**COMMUNITY SERVICES DEPARTMENT**  
PARK OPERATIONS ~ ENVIRONMENTAL SERVICES ~ RECREATION/CULTURAL SERVICES

**Subject: Forest Heights Minor Subdivision (MS-206)**

The Community Services Department has reviewed the Forest Heights Minor Subdivision. The following review was presented to the Park Advisory Board and the recommended motion was endorsed on January 13, 2021:

FOREST HEIGHTS ESTATES

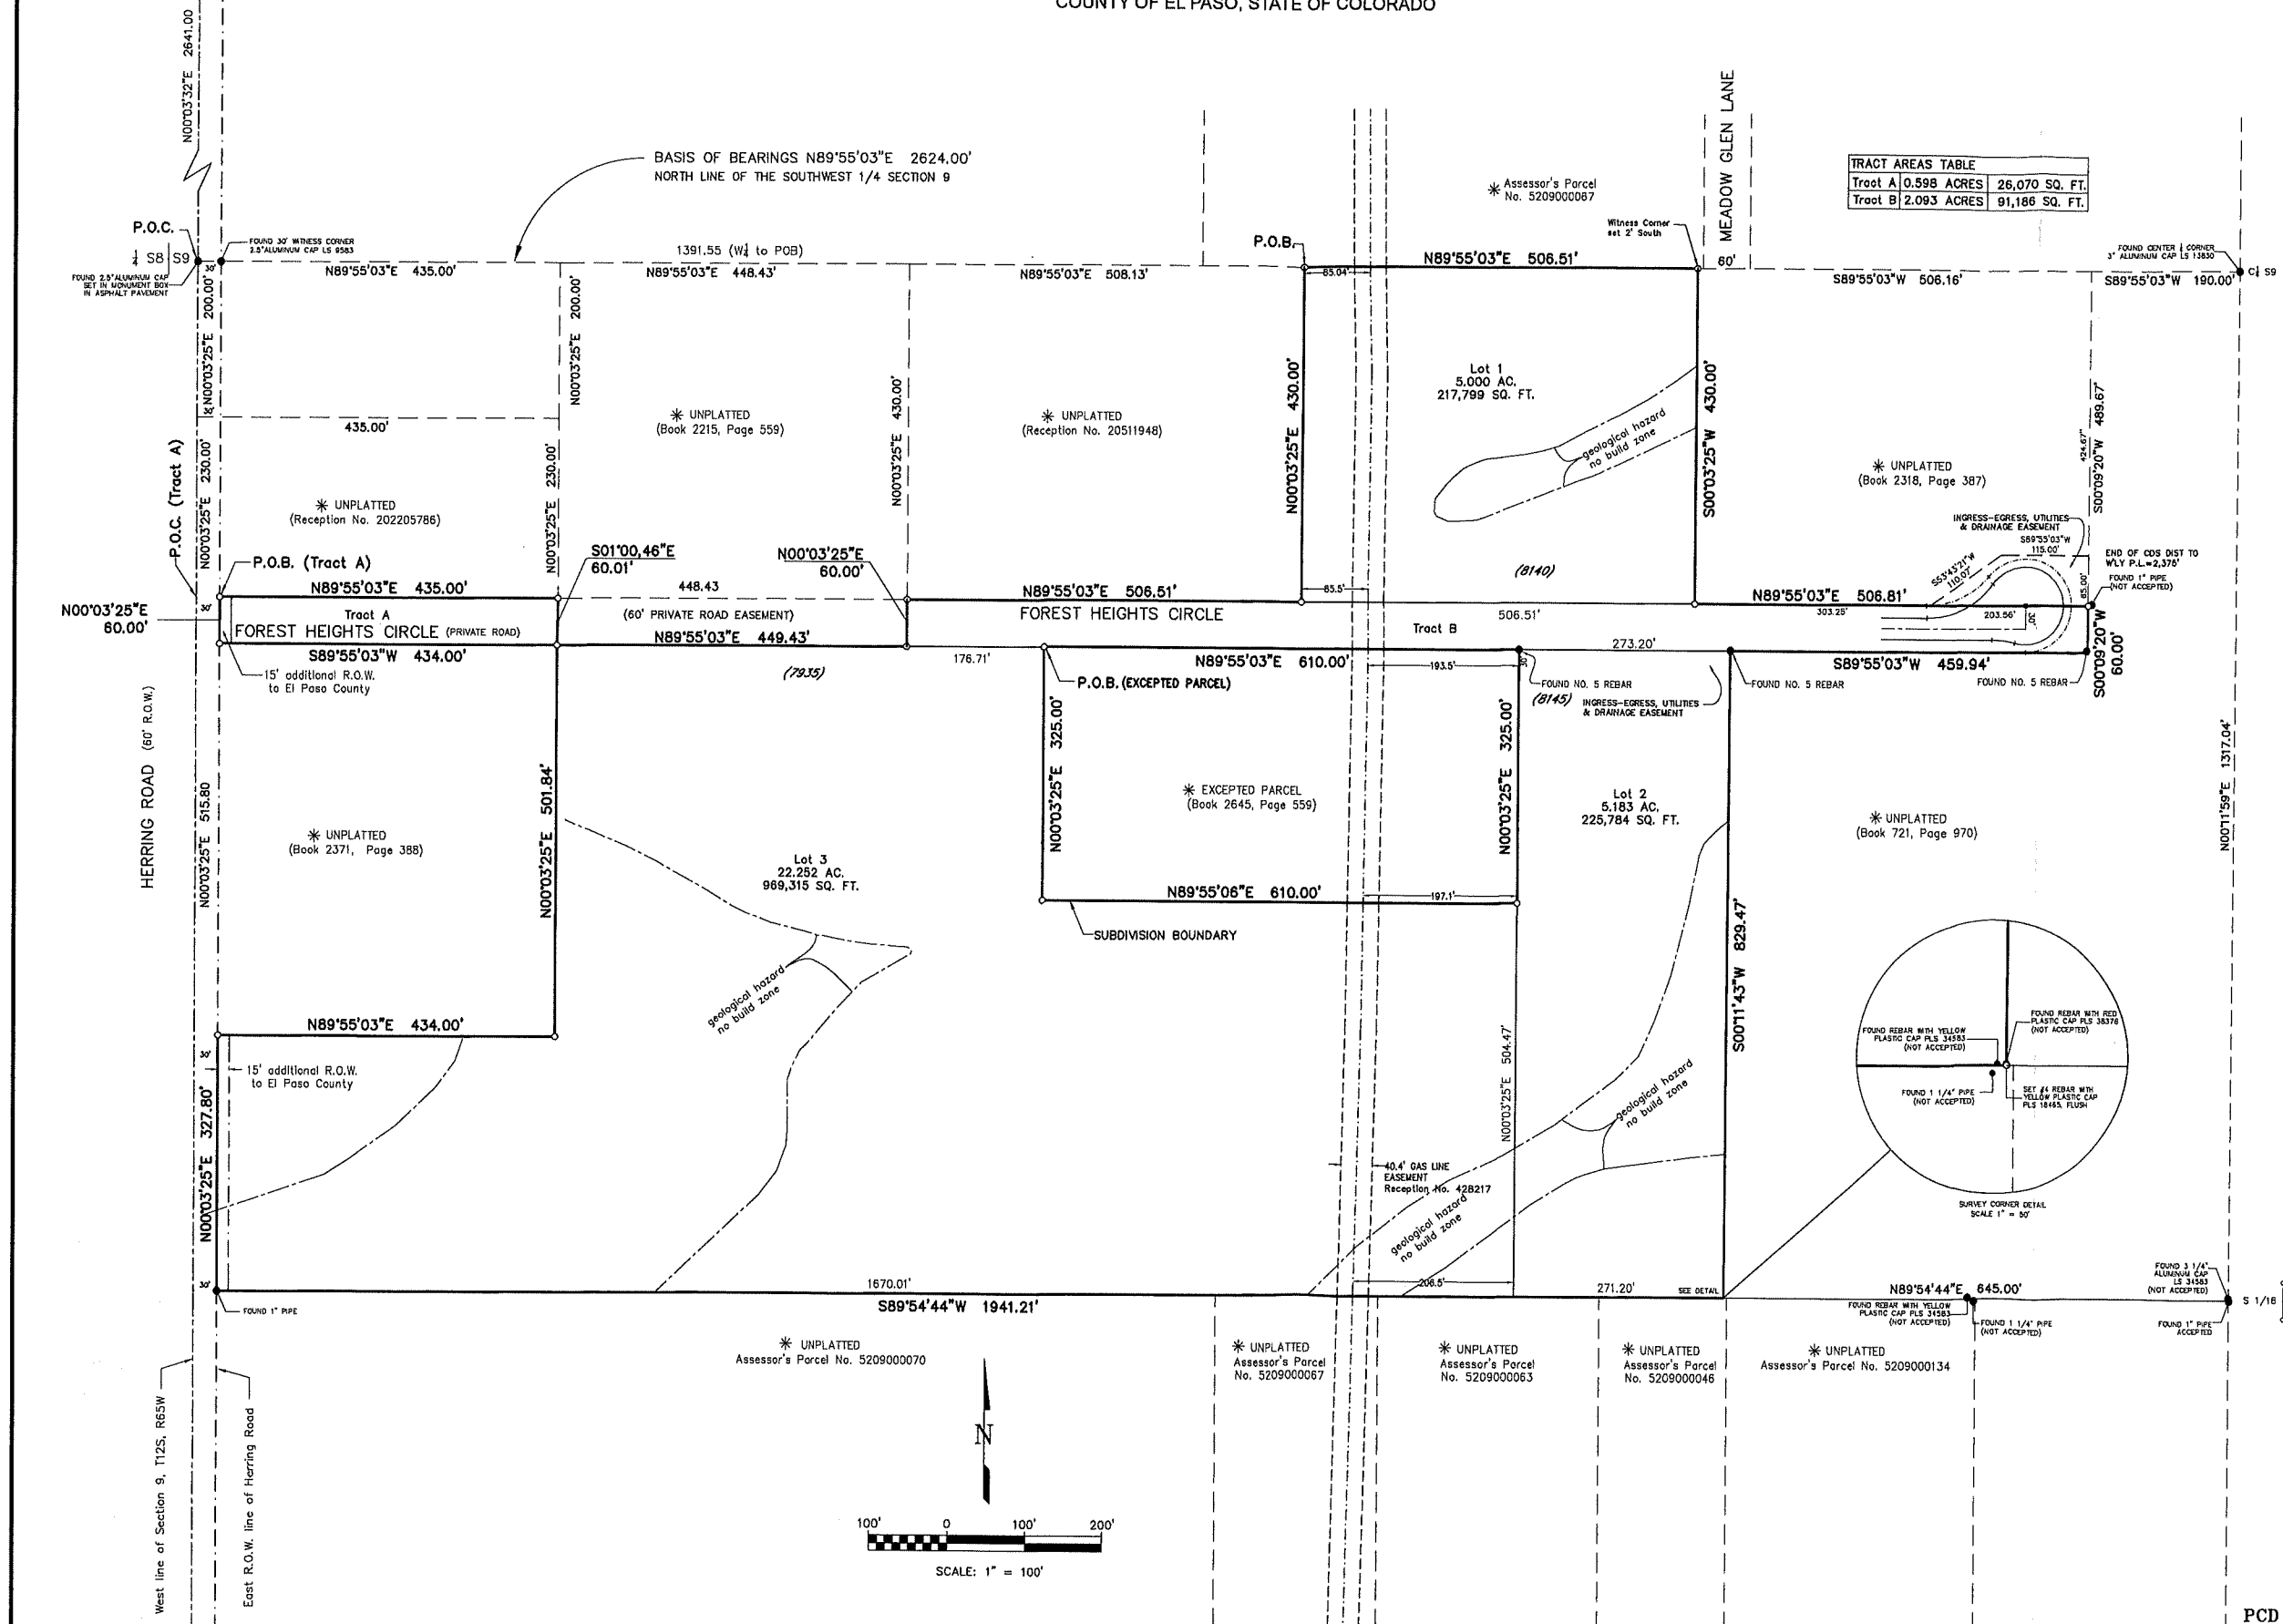
*County Parks requests trail easements where development projects impact proposed to County trails. As it pertains to this application, the County requests that the landowner provide a 25-foot public trail easement shown in the existing gas pipeline easement that allows for the construction and maintenance*

*by El Paso County of a secondary regional trail, and this easement shall be shown and dedicated to El Paso County on the Final Plat.*

The final plat now shows 3 proposed lots instead of 4. Because of this, the park fees will be reduced to reflect regional park fees for 3 lots. The updated recommendation is below in bold:

**The Park Advisory Board recommends that the Planning Commission and the Board of County Commissioners include the following condition when considering and / or approving the Forest Heights Minor Subdivision include the following condition: (1) Fees in lieu of land dedication for regional park purposes in the amount of \$1,401 will be required at time of the recording of the final plat. (2) Designate and provide to El Paso County a 25-foot trail easement along the existing gas pipeline easement that allows for the construction and maintenance by El Paso County of the Pipeline Secondary Regional Trail.**
